From: Nicola Spencer on behalf of Planning.Responses
Sent: 04 September 2026 12:17
To: Planning Scanning
Subject: FW: Planning Consultation on: BR/134/26/PL

From: Christian Melgar <Christian.Melgar@arun.gov.uk> **On Behalf Of** HMOLicensing
Sent: 03 September 2026 15:57
To: Planning.Responses <Planning.Responses@arun.gov.uk>
Subject: RE: Planning Consultation on: BR/134/26/PL

Application No: BR/134/26/PL

Description of Works: Change of use from dwelling house (use class C3) to 8-bed, 8-person house in multiple occupation (Sui Generis) to include a rear extension and loft conversion. This application is in CIL Zone 4 (Zero Rated) as other development.

Drawing No: 260107 - 3.01 Rev: B

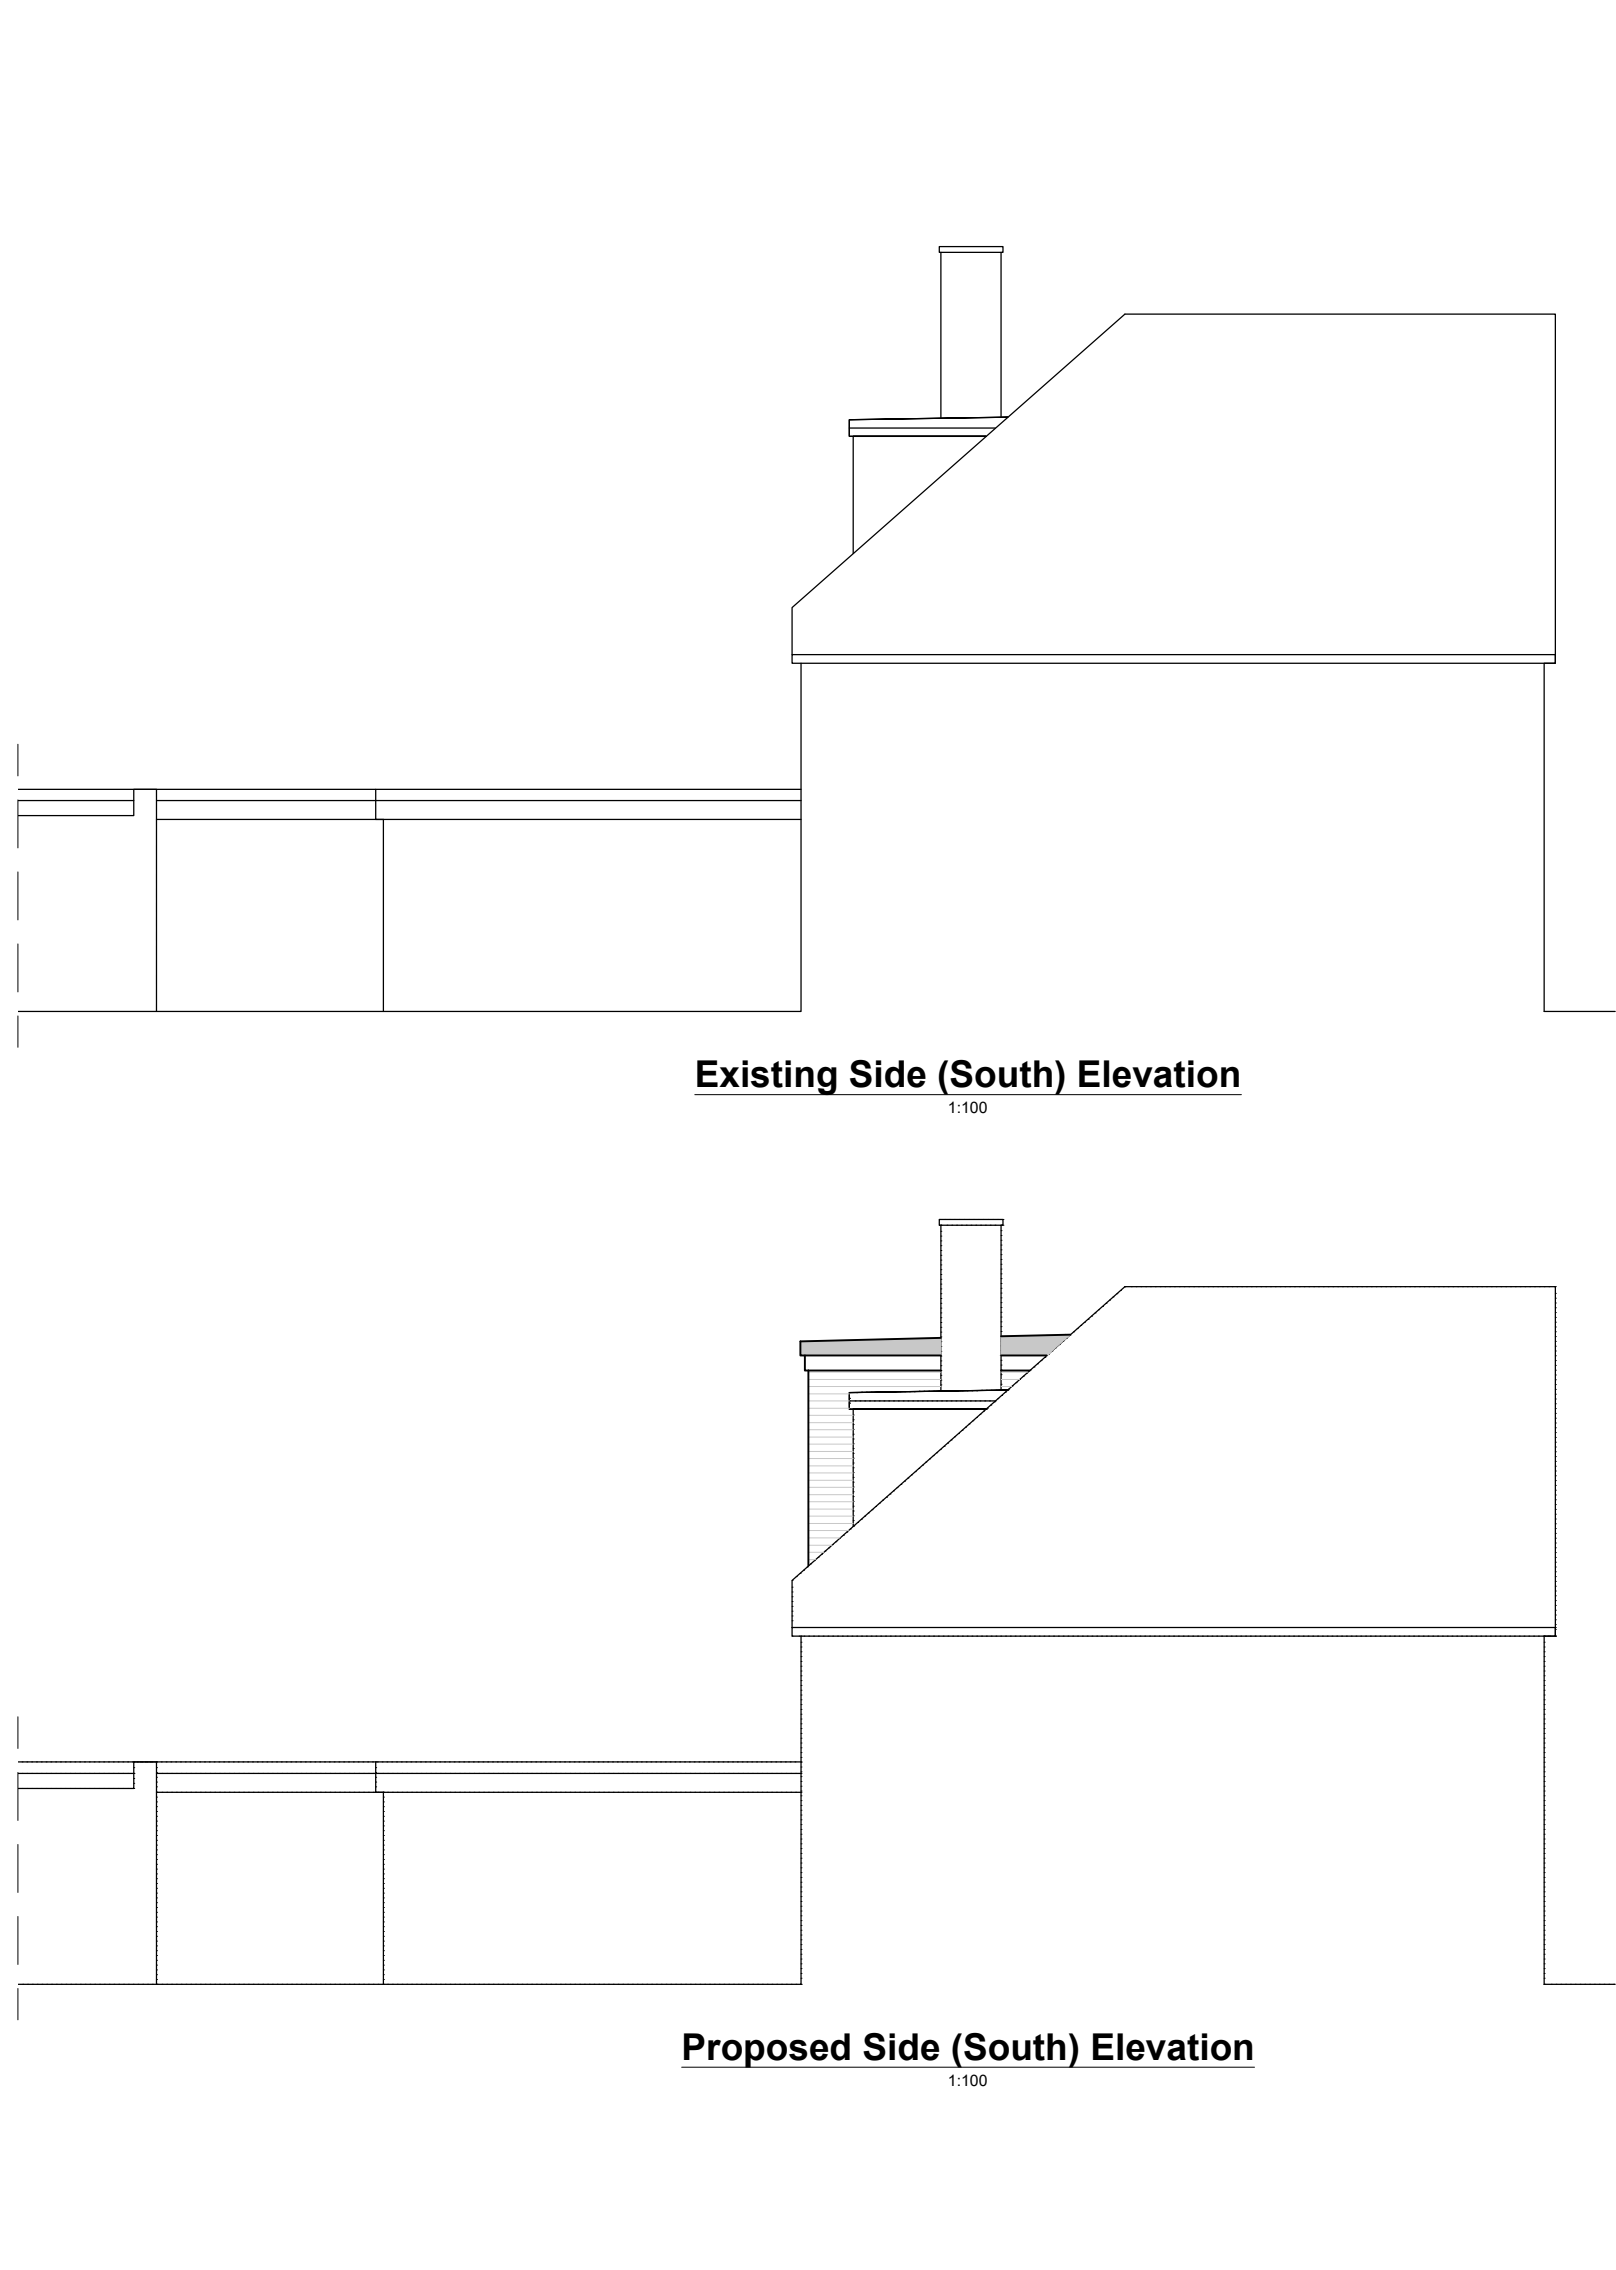
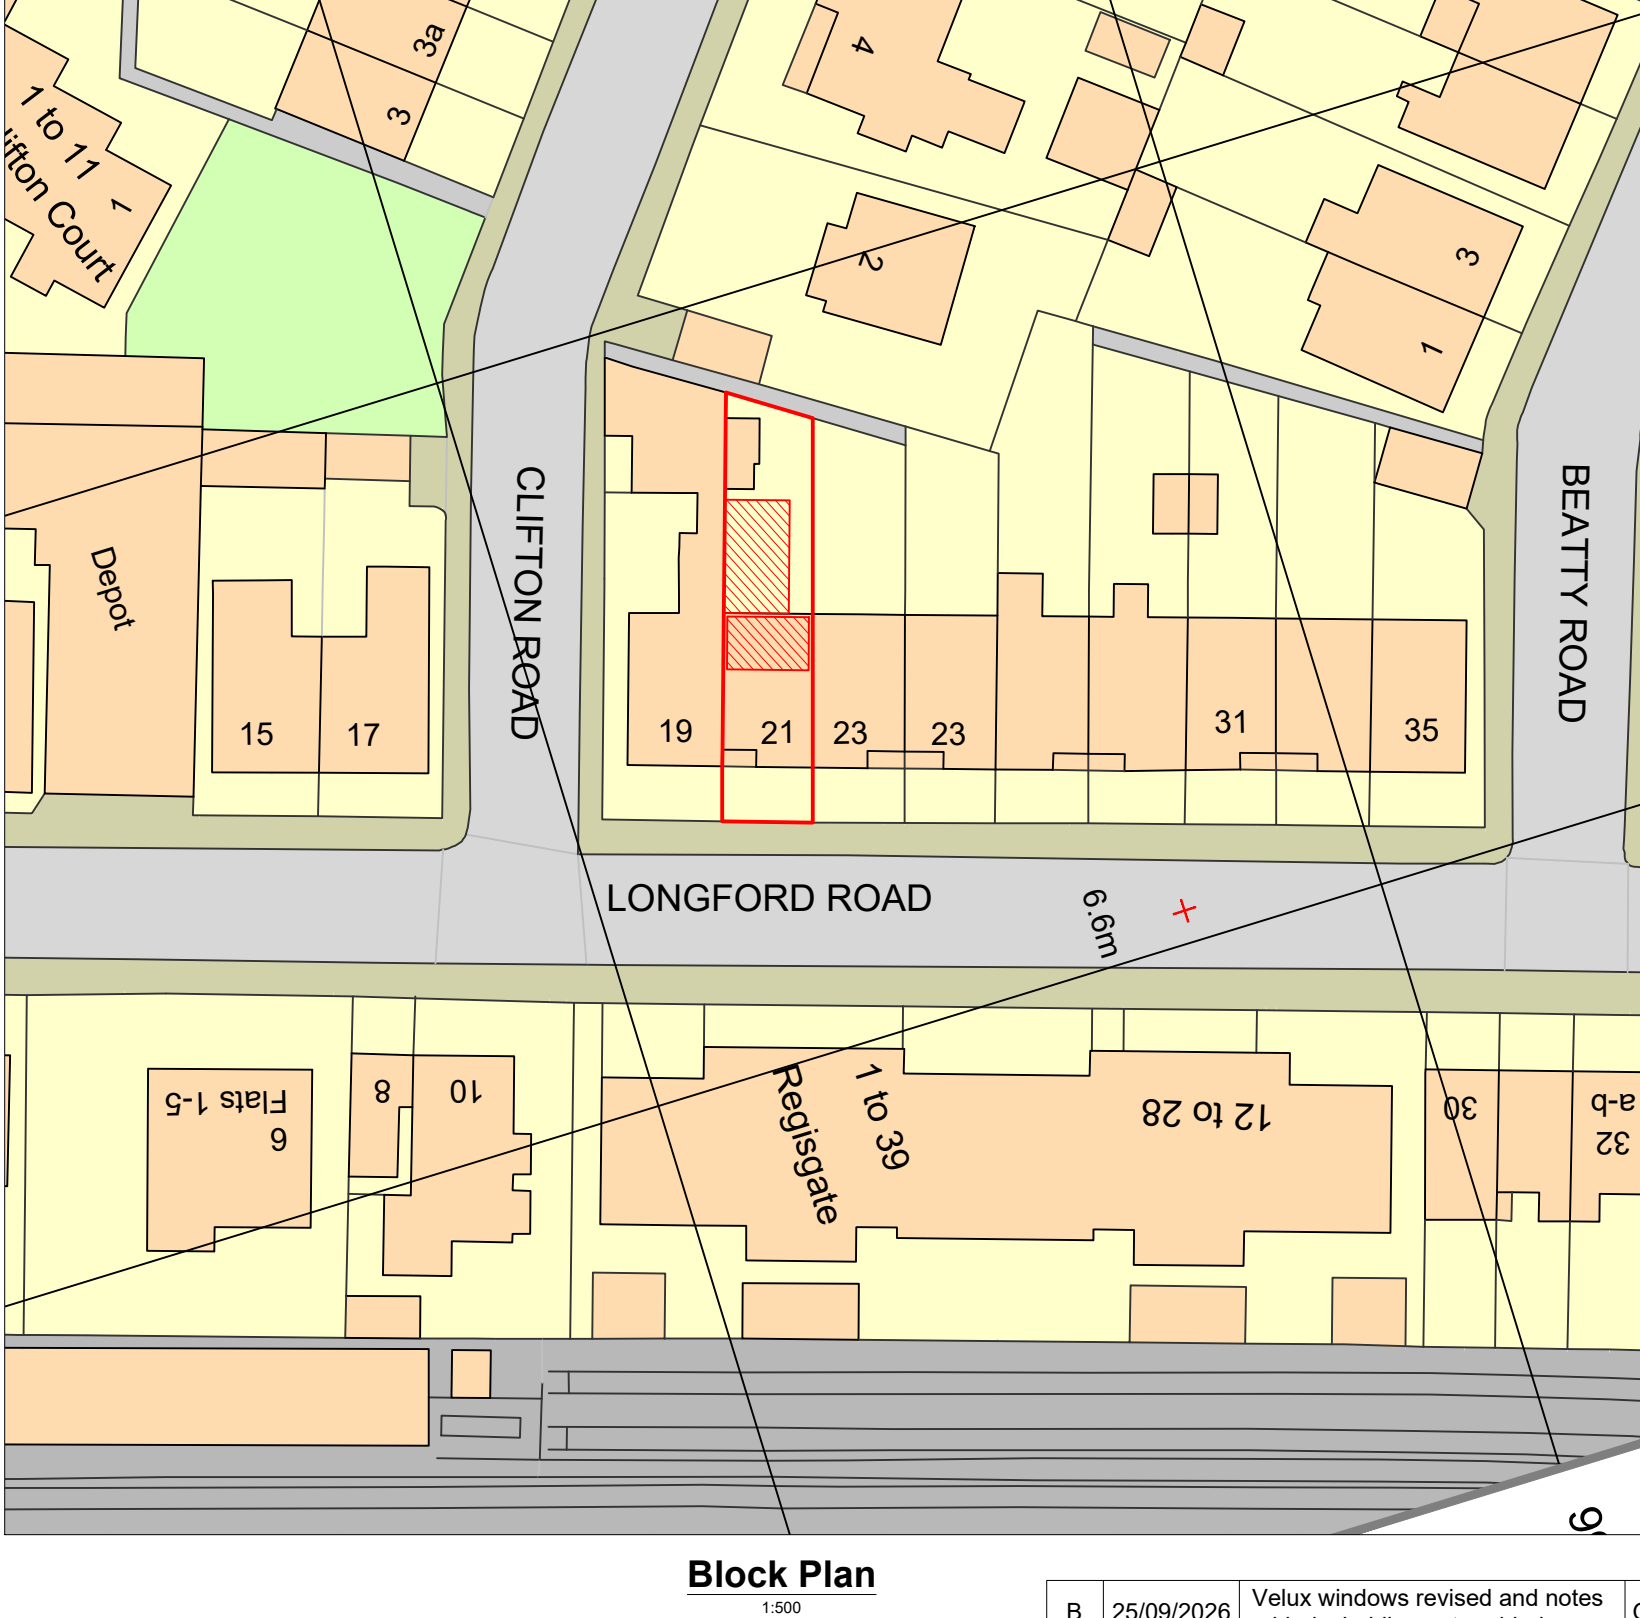
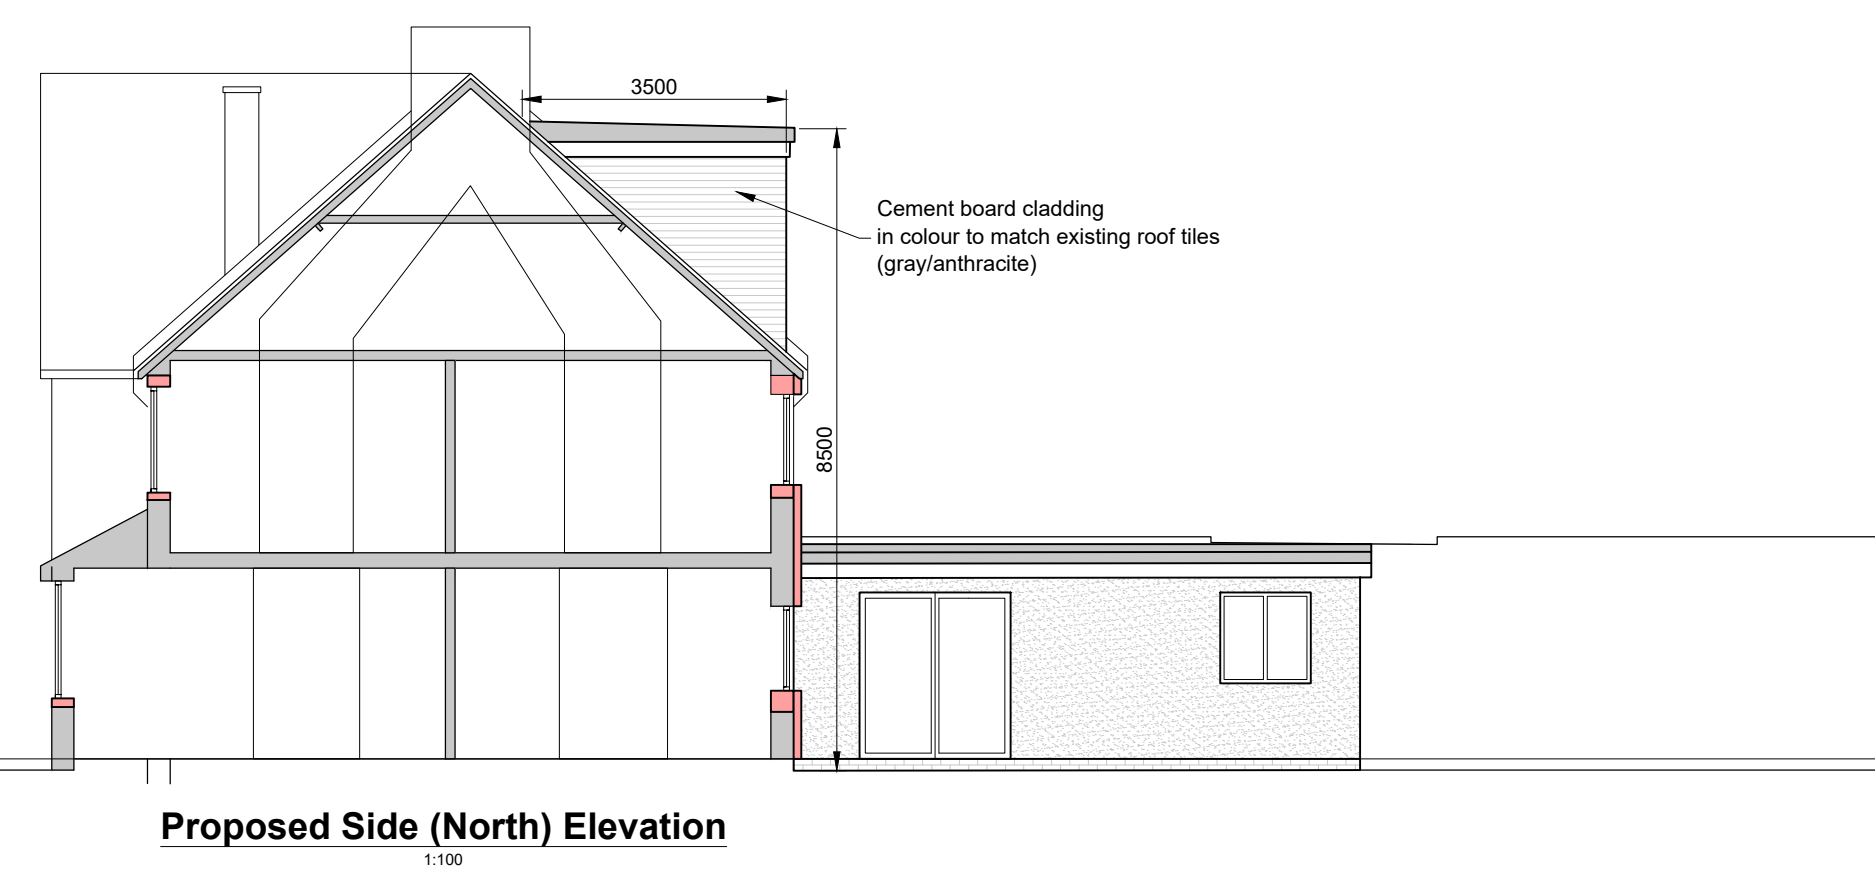
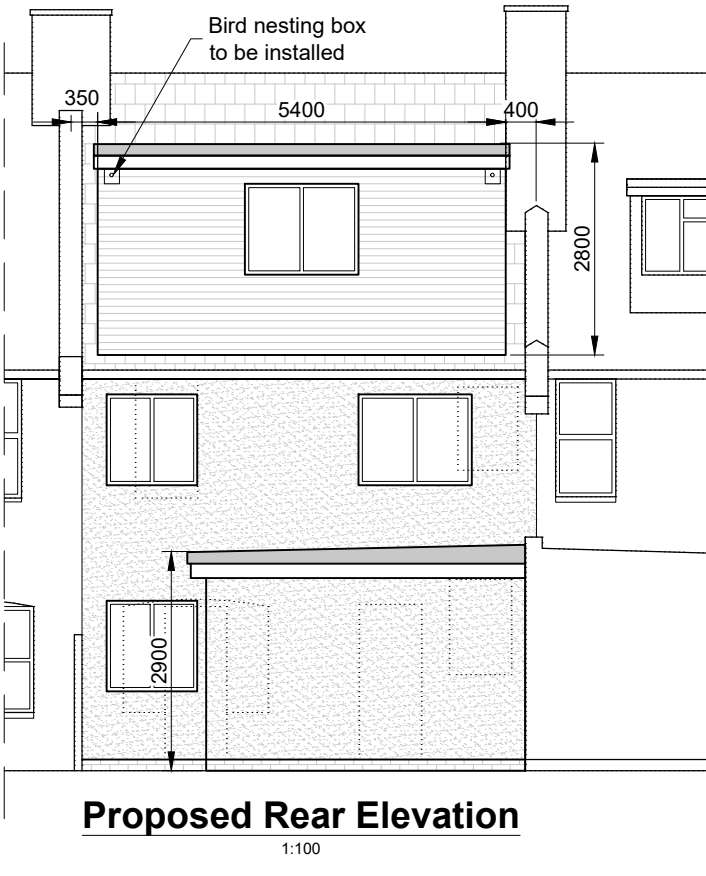
Bedroom 2 – The egress route for Bedroom 2 in the event of a fire is through the communal dining area which is a higher risk area and an “inner” room. The window to this room must therefore be a suitable escape window. Requirements for escape windows are detailed below.

Bedroom 3 – The egress route for Bedroom 2 in the event of a fire is through the communal dining area which is a higher risk area and an “inner” room. The window to this room must therefore be a suitable escape window. Requirements for escape windows are detailed below.

Bedroom 7 – The room does not have any windows that provide a suitable view - only a view of the sky is considered likely from the size and positioning of the proposed window. HHSRS operating guidance states that *“Windows should be large enough and at a level where occupiers are provided with a reasonable view of the surroundings, when in a seated position in the living areas of the dwelling... Views should be over at least six metres of space outside of the windows of one room, with a view of the landscape outside the building.”* A larger or lower positioned skylight/velux would allow for an additional viewing area. The window must be at least 1/5th of the floor area of the room and be openable to allow effective ventilation at any time, as well as effective ventilation during times when it is raining and the window cannot be opened fully as it would allow ingress of rainwater.

En-suite shower rooms – All shower rooms and bathrooms (whether shared or used by an individual), including en-suite shower rooms must be provided with a full-sized wash hand basin, i.e. cloakroom wash hand basins are not considered appropriate except for a compartment that contains a WC only. Bathrooms/shower rooms/en-suites must also provide a bath/shower, WC (unless an alternative is available), appropriate heating, mechanical extract ventilation to the outside air, appropriate splashbacks to basins and suitable floor covering (carpet is not considered suitable). Bathrooms, shower rooms and en-suites must provide a suitable amount of space so that occupants can dry themselves within the compartment and without the need to exit the compartment into the main bedroom area.

Requirements for escape windows - Any window provided for emergency escape purposes must have an unobstructed openable area that is at least 0.33m² and have a minimum 450mm height and 450mm width. The bottom of the openable area should not be more than 1,100mm above the floor. Escape windows can only be considered if satisfied that it would be safe to use them in an emergency. They should meet the following criteria:
